Engineers Comments Regarding Surface Water Drainage

Application Reference:	AL/6/25/DOC	Reviewer Reference:	ADC/EXT4
Planning Officer:	Hannah Kersley	Date of Review:	01/10/2025
Site Name:	8 Autumn Gate Hook Lane Aldingbourne PO20 3TE		
Application Description:	Approval of details reserved by condition imposed under reference AL/75/24/HH relating to condition number 4 - surface water drainage scheme.		
Assessment Number:

Condition 4: **Objection**

PROPOSED DRAINAGE STRATEGY (scale 1:100)

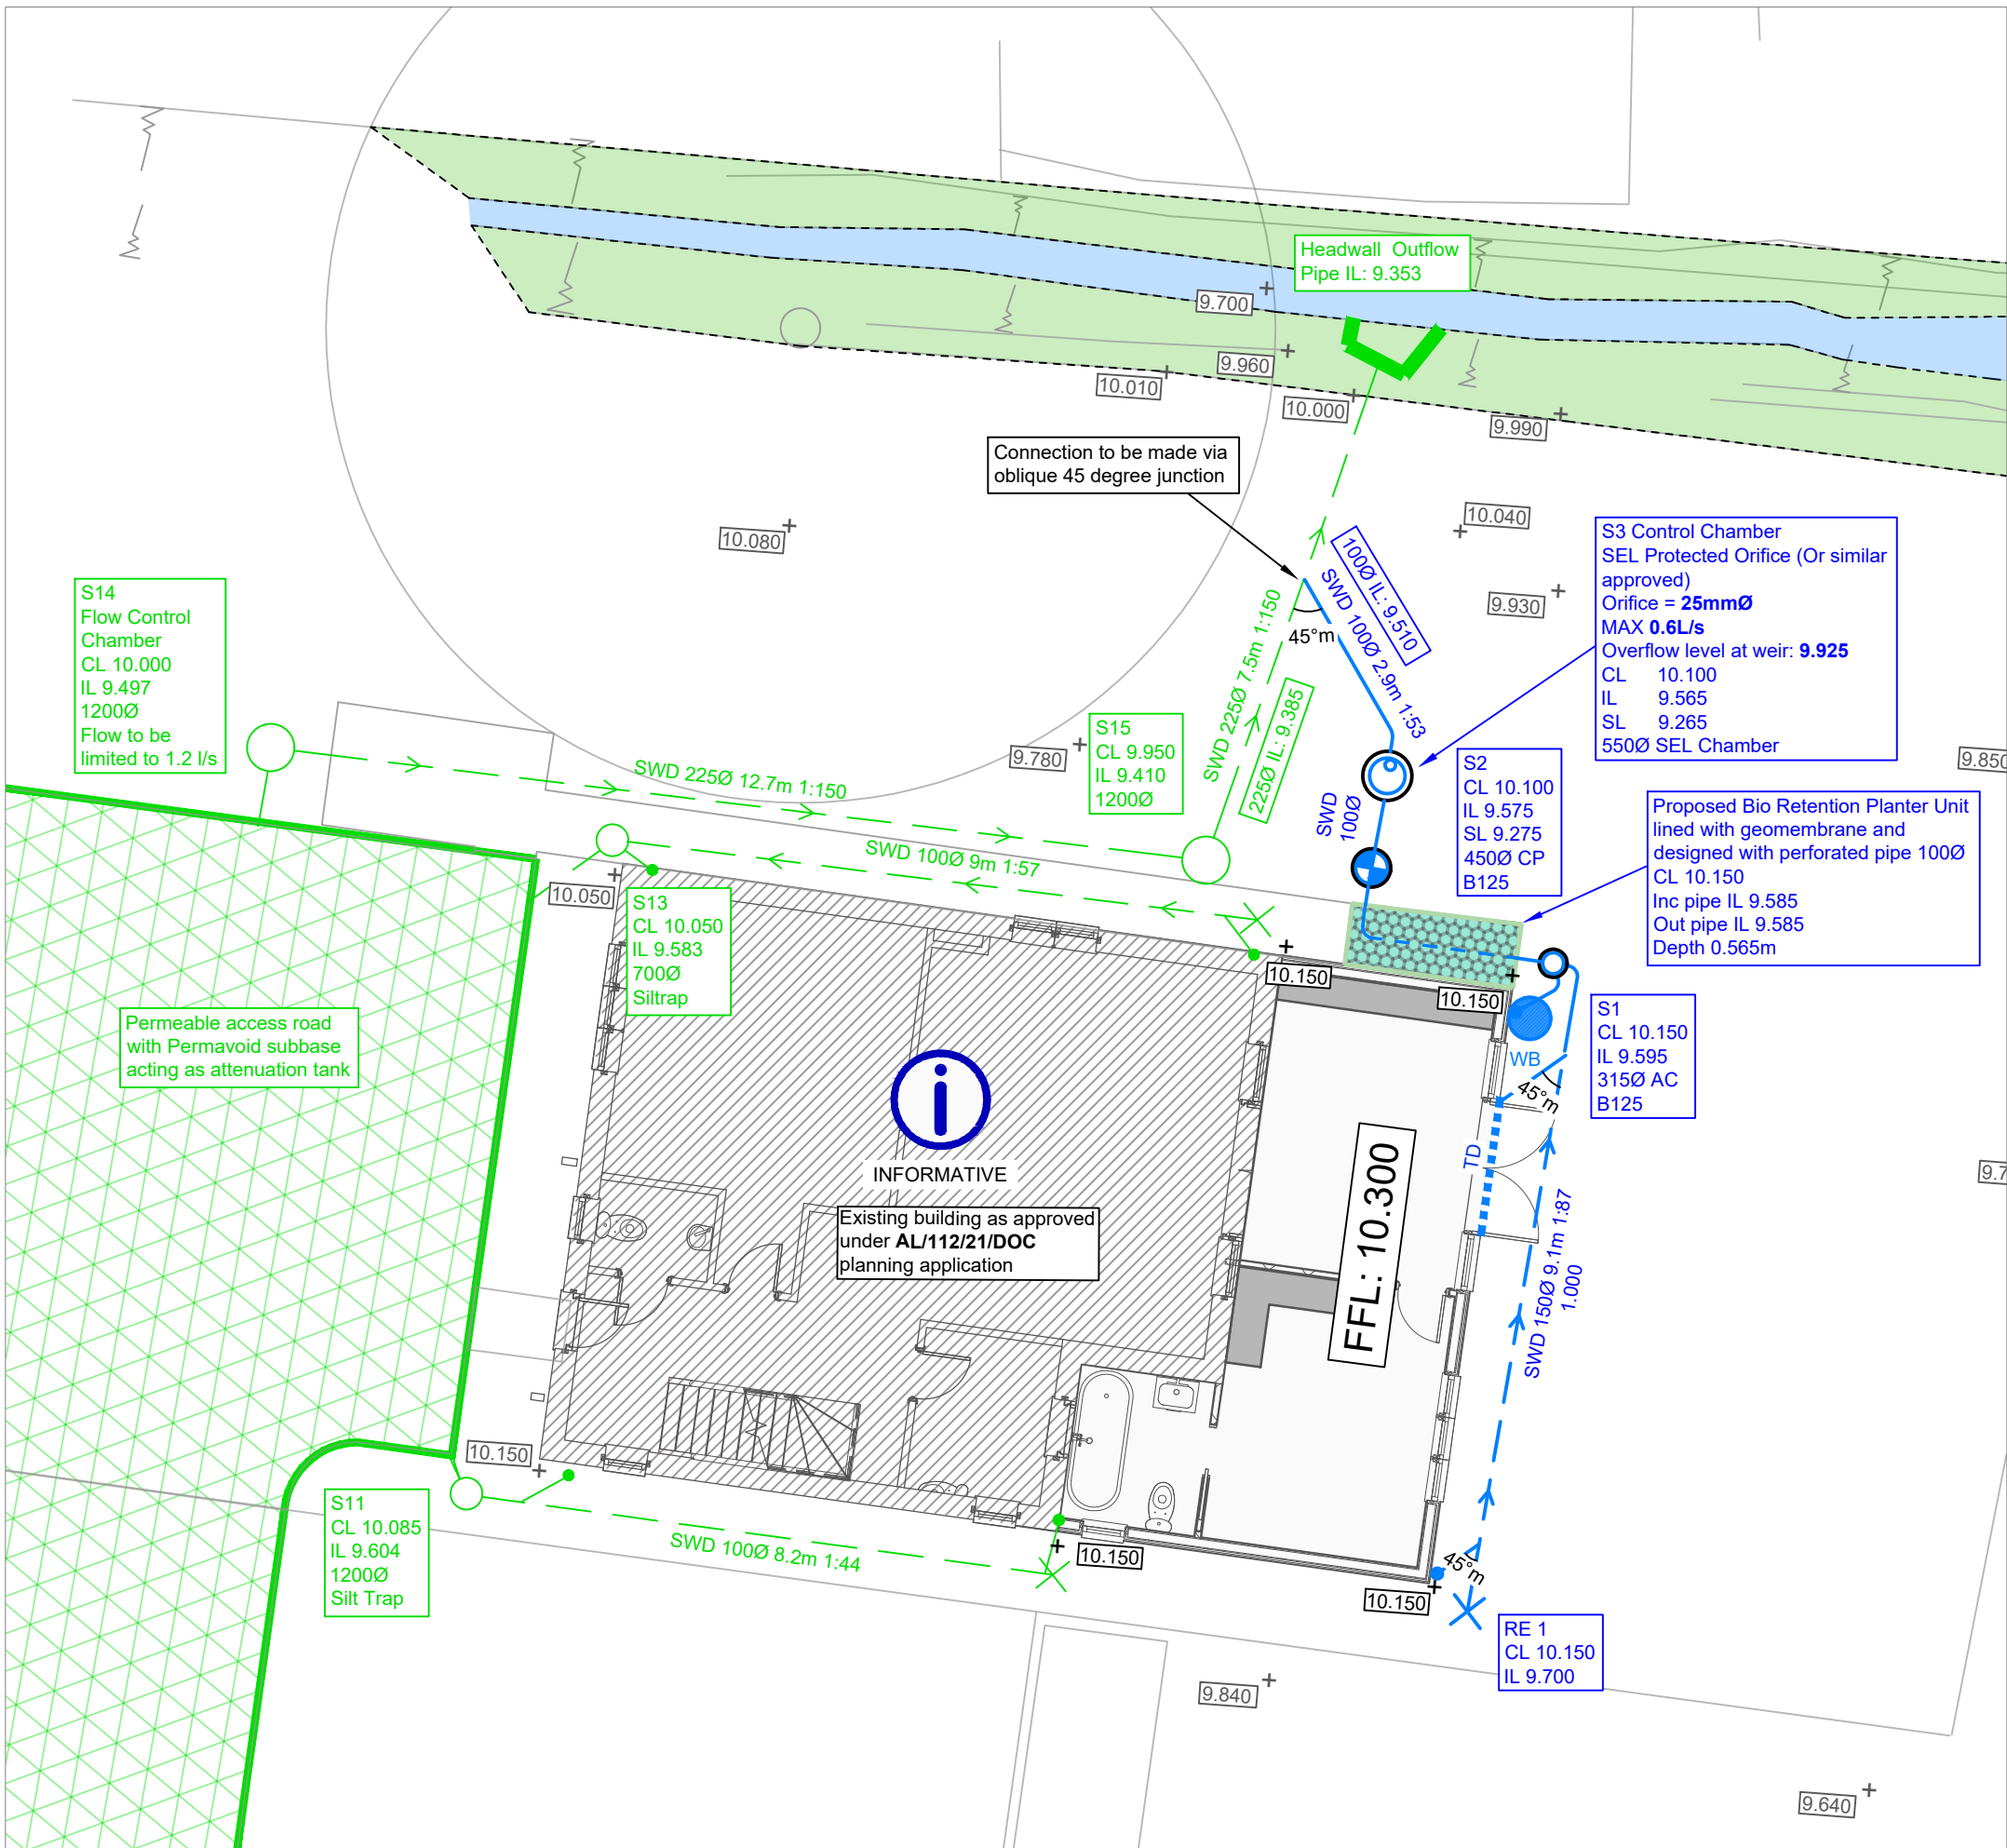
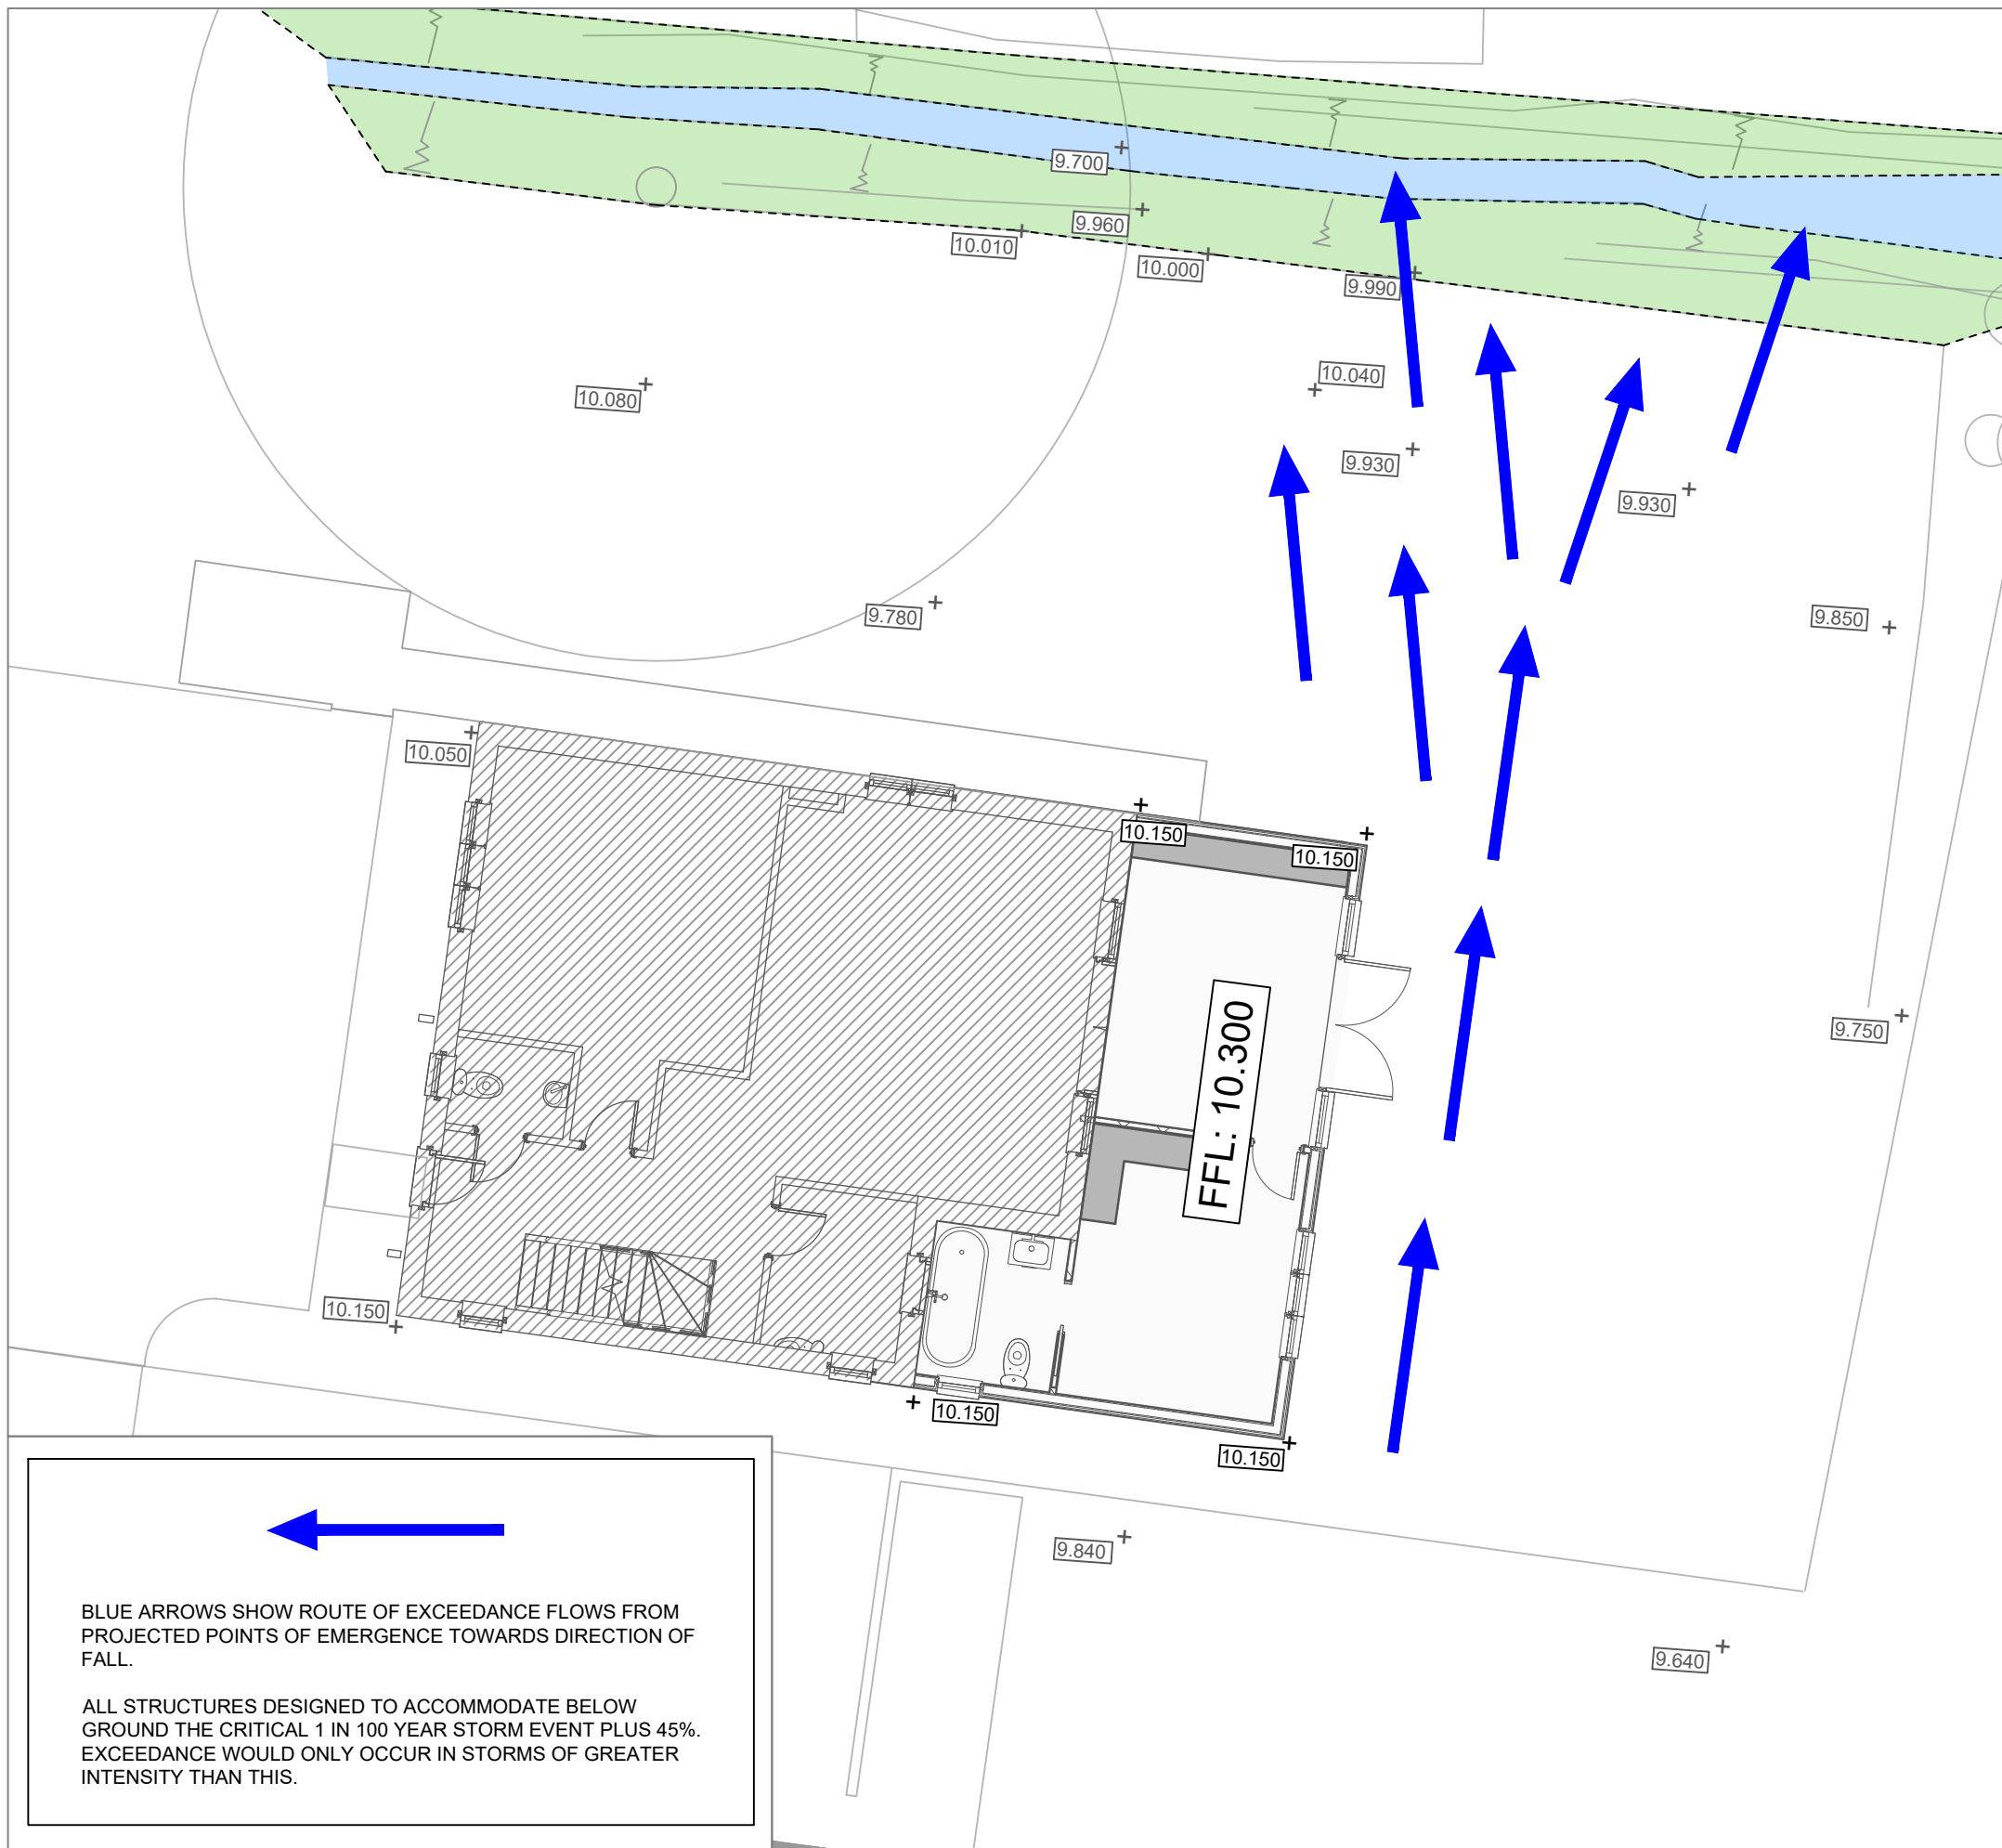
ADC Drainage Comments	Designer Response	ADC Drainage Comments		
Date:	26/08/2025	04/09/2025	01/10/2025		
Condition Number:					
Comment Number					
1.	ADC Drainage Response (AL-6-25-DOC) 15/07/2025 Where the existing pipe is being connected to, specify an oblique 45 degree junction or new manhole. Designer response (AL-6-25-DOC) 25/07/2025 Updated. The oblique 45 degree ensured. ADC Drainage Response (AL-6-25-DOC) 26/08/2025 Please advise where the drawing has been updated to reflect this.	Noted. The oblique 45 degree junctions have been described and marked on the drawing , indicating their exact locations. Please refer to the Proposed Drainage Strategy Rev P2.	Item now closed

4.	ADC Drainage Response (AL-6-25-DOC) 15/07/2025 Where the threshold drain is being connected to pipeline Re1 to S1, specify an oblique 45 degree junction. Similar comment for the RWP on the SE corner Designer response (AL-6-25-DOC) 25/07/2025 Updated. ADC Drainage Response (AL-6-25-DOC) 26/08/2025 Clearly indicate that these connections will be made using oblique 45 degree junctions.	Noted. The oblique 45 degree junctions have been described and marked on the drawing, indicating their exact locations. Please refer to the Proposed Drainage Strategy Rev P2.	Noted and closed

450mmØ/600mmØ Turtle Enviro Silt Trap Detail
(scale 1:20)

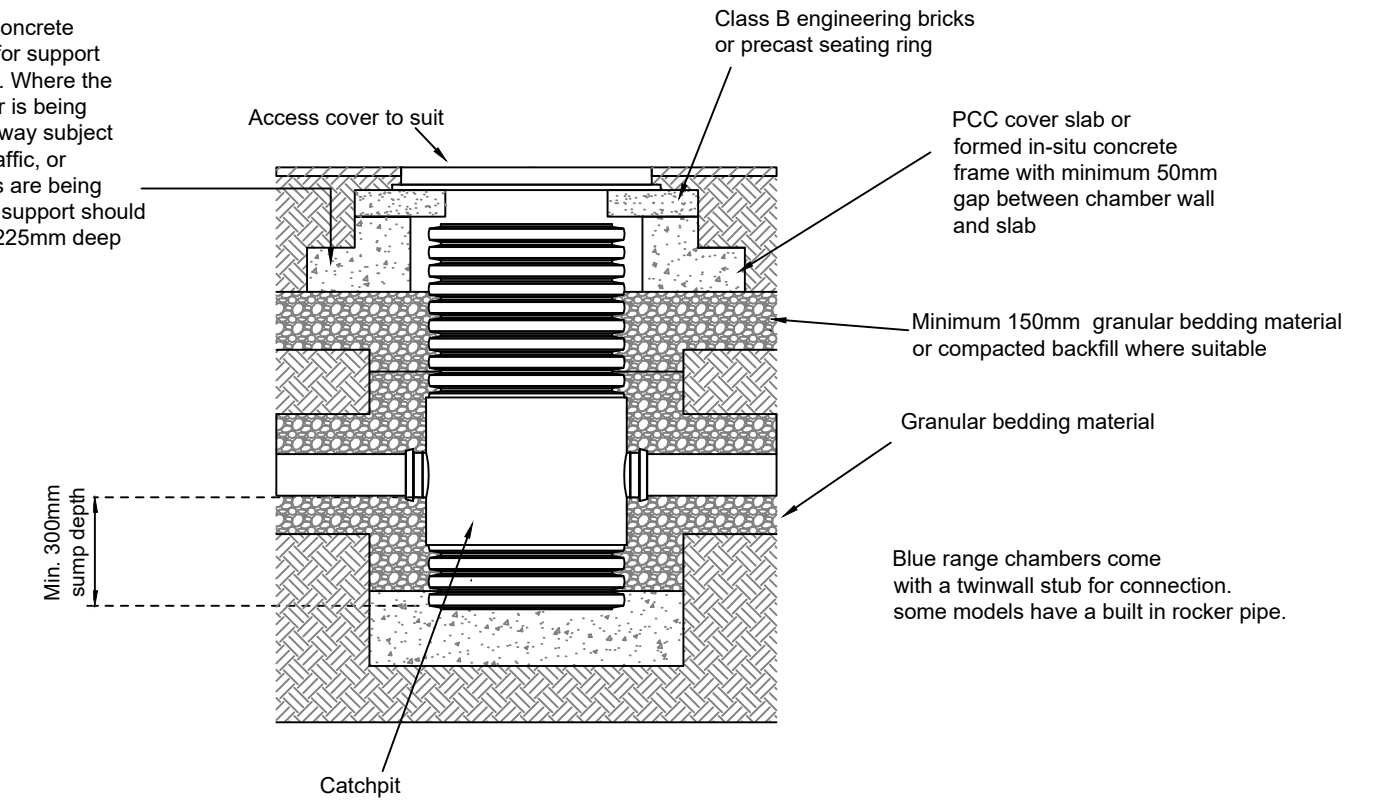
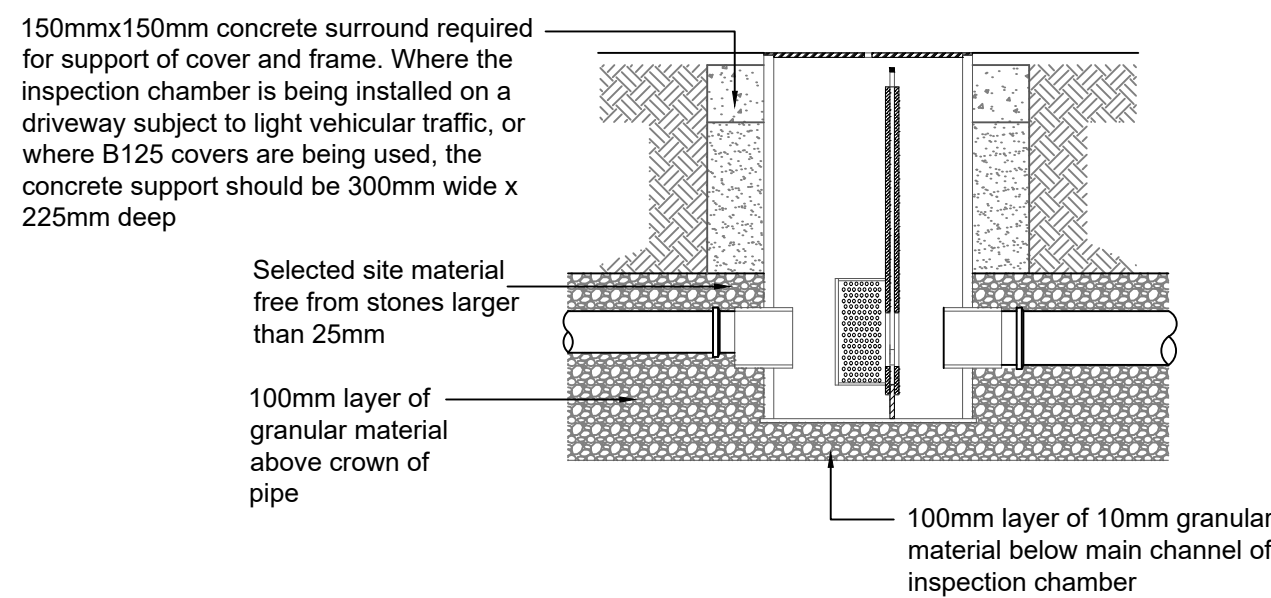
3.	ADC Drainage Response (AL-6-25-DOC) 15/07/2025 Provide a suitable catchpit upstream of the flow control chamber, ensuring all flows have to pass through this chamber. Include full construction details. Designer response (AL-6-25-DOC) 25/07/2025 Updated. ADC Drainage Response (AL-6-25-DOC) 26/08/2025 Specify sump depth on construction detail	Noted. It has been updated- please see Proposed Typical Construction Details Rev. P2	Noted and closed
